Request for Advice

Application No. **SSD-93020230**
Property Address **40-48 Redan Street, Mosman**

Thank you for your correspondence dated 11 March 2026 inviting Mosman Council (Council) to comment on the exhibition of State Significant Development (SSD Application No. SSD-93020230 for the demolition of existing dwellings and ancillary structures, and the construction of a 10-storey residential flat building development comprising 53 residential units (including 11 in-fill affordable housing units), 106 car parking spaces (including 10 visitor spaces) over 2 levels of basement parking.

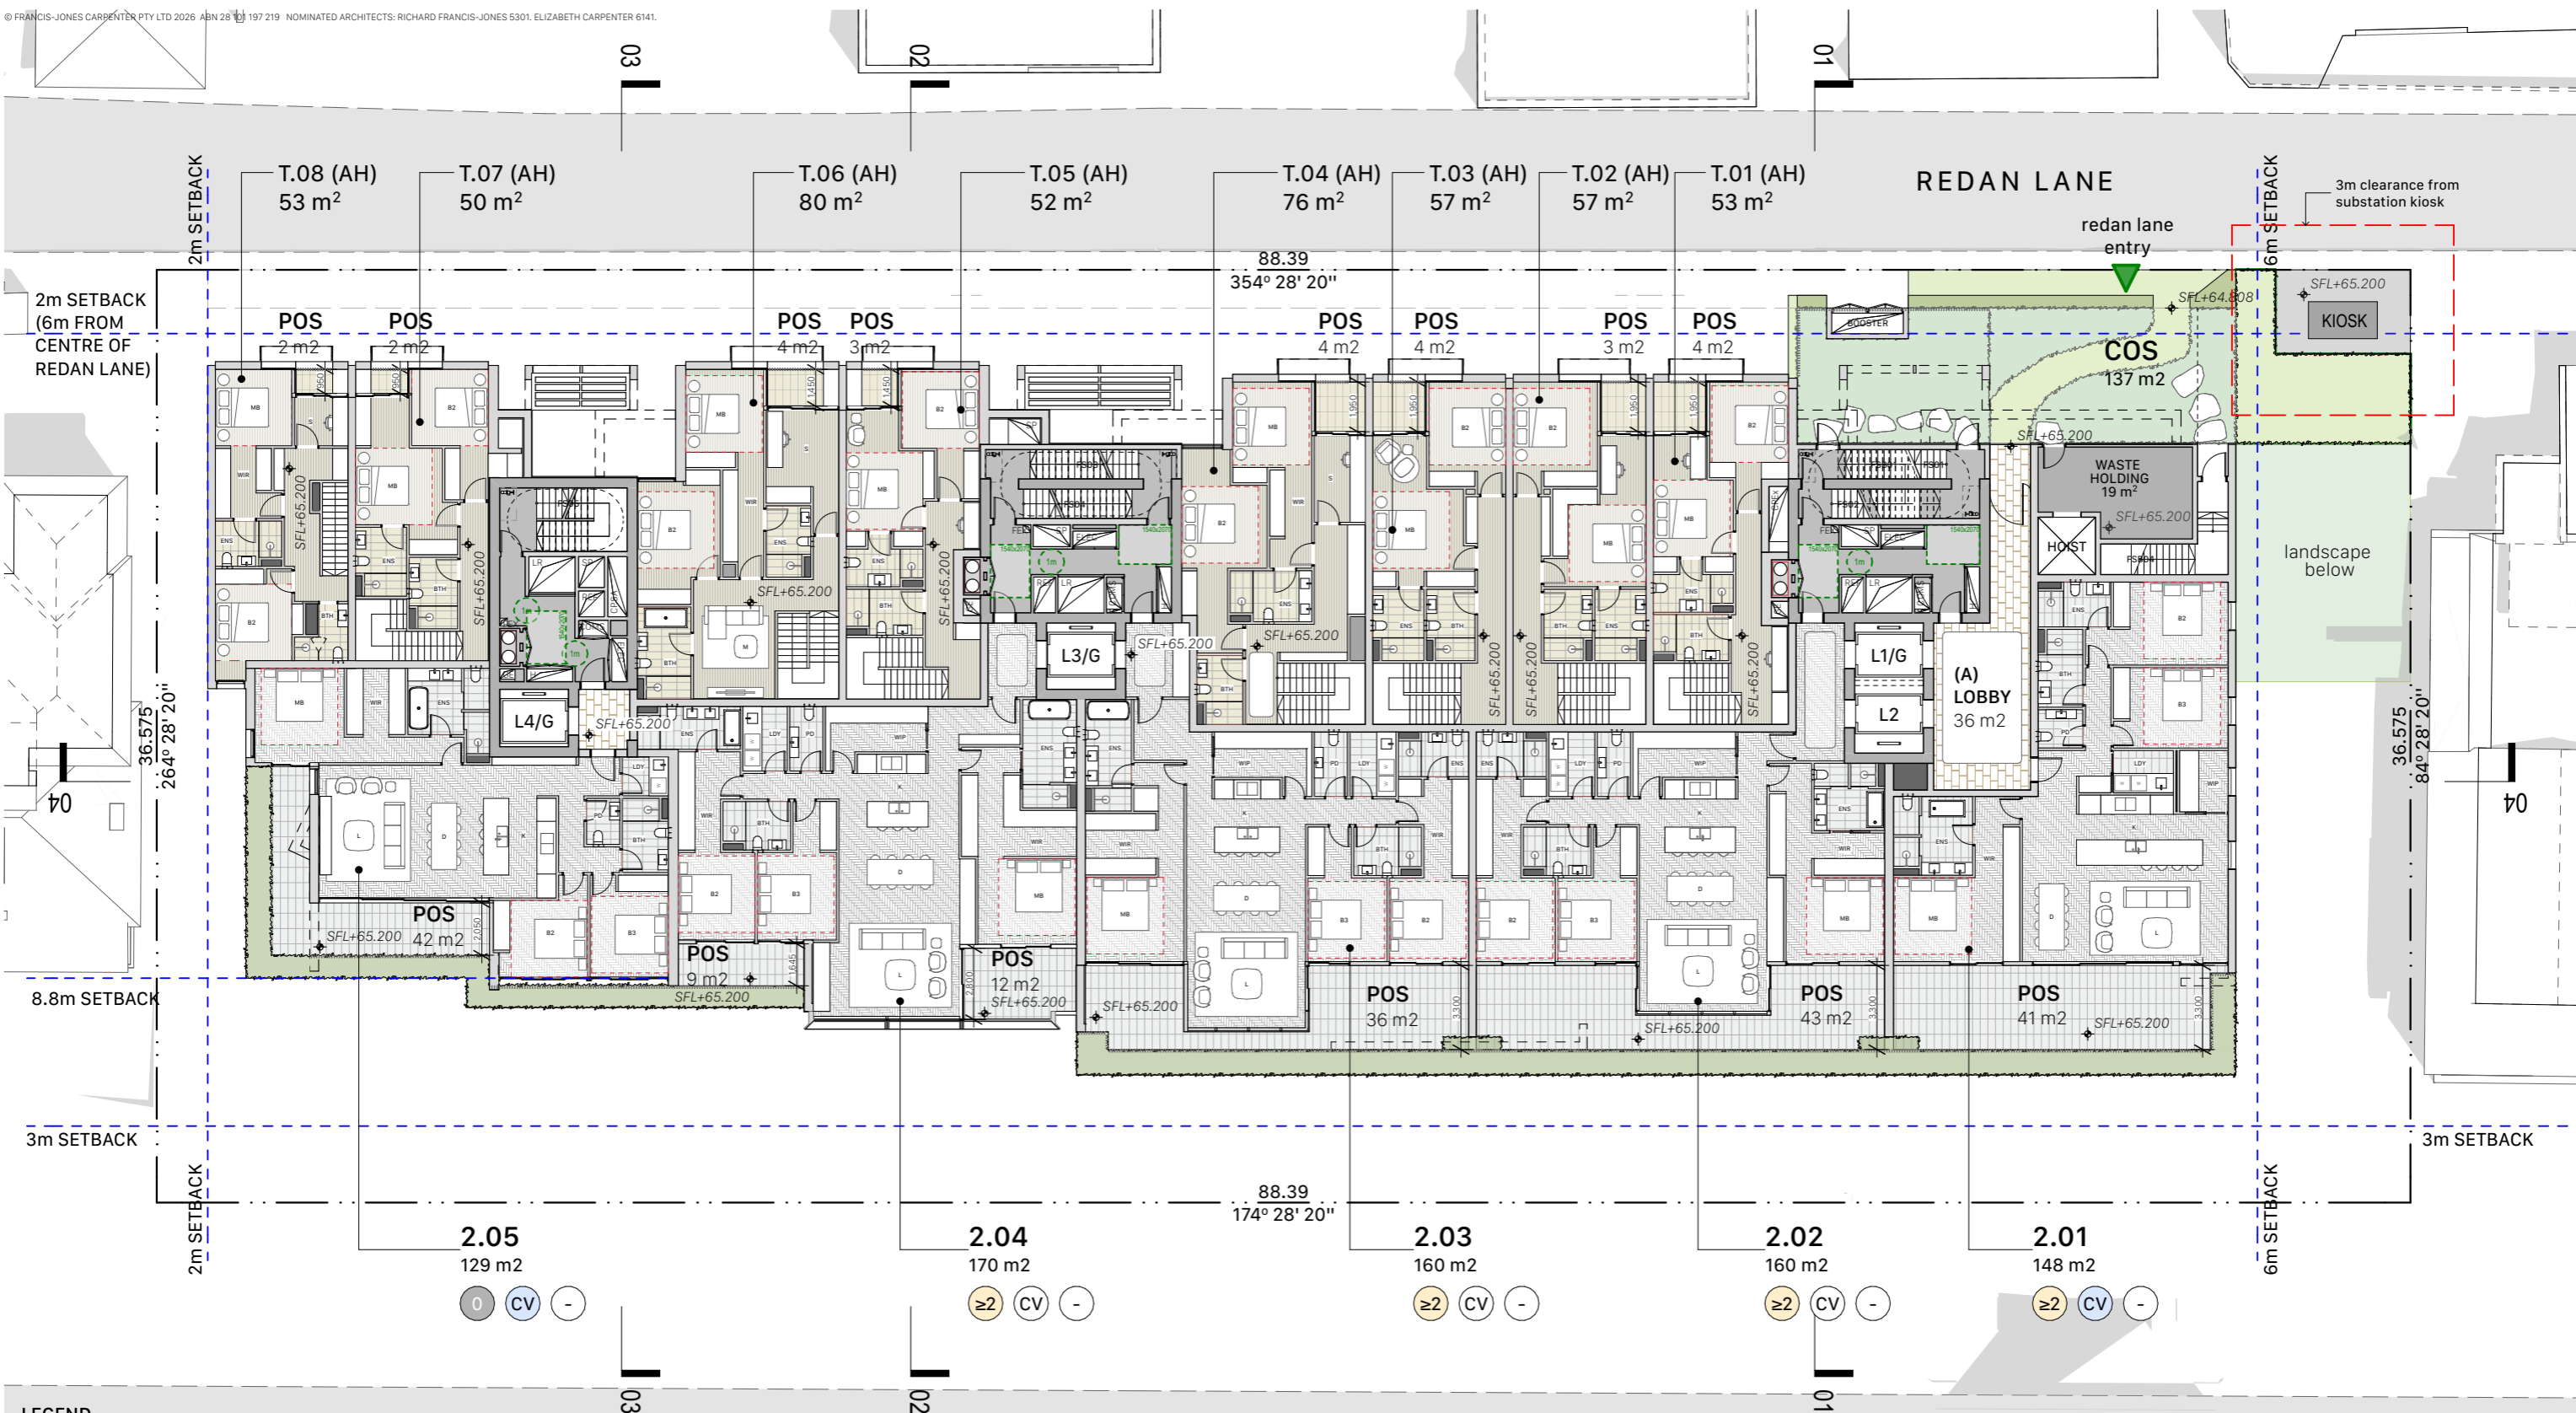
Waste collection is currently proposed from the lane. However, there are concerns that the volume of garbage that needs to be collected will require collections to be provided between 2 to 3 times a week, which will impact on the functionality of the lane. This issue will likely be compounded when neighbouring sites are developed with increased densities. The introduction of on-site waste collection would assist in reducing the proposal's impact upon the lane and set a precedent for future developments to come.

To provide on-site waste collection from the lane a turntable would be required on Level 2 of the development. This would necessitate the re-planning of this level to accommodate a HGV turn table (range in size between 9 and 11m) and an increased floor to floor height for the northern portion of Level 1. The diagram below shows the scale and suggested location of a HGV turn table (note: the diagram is not intended to be a resolved design proposal). Swept path diagrams (provided by a traffic engineer) are required to establish how a garbage truck would enter and exit the site. This may impact the location of the turntable and require an increased laneway building setback.
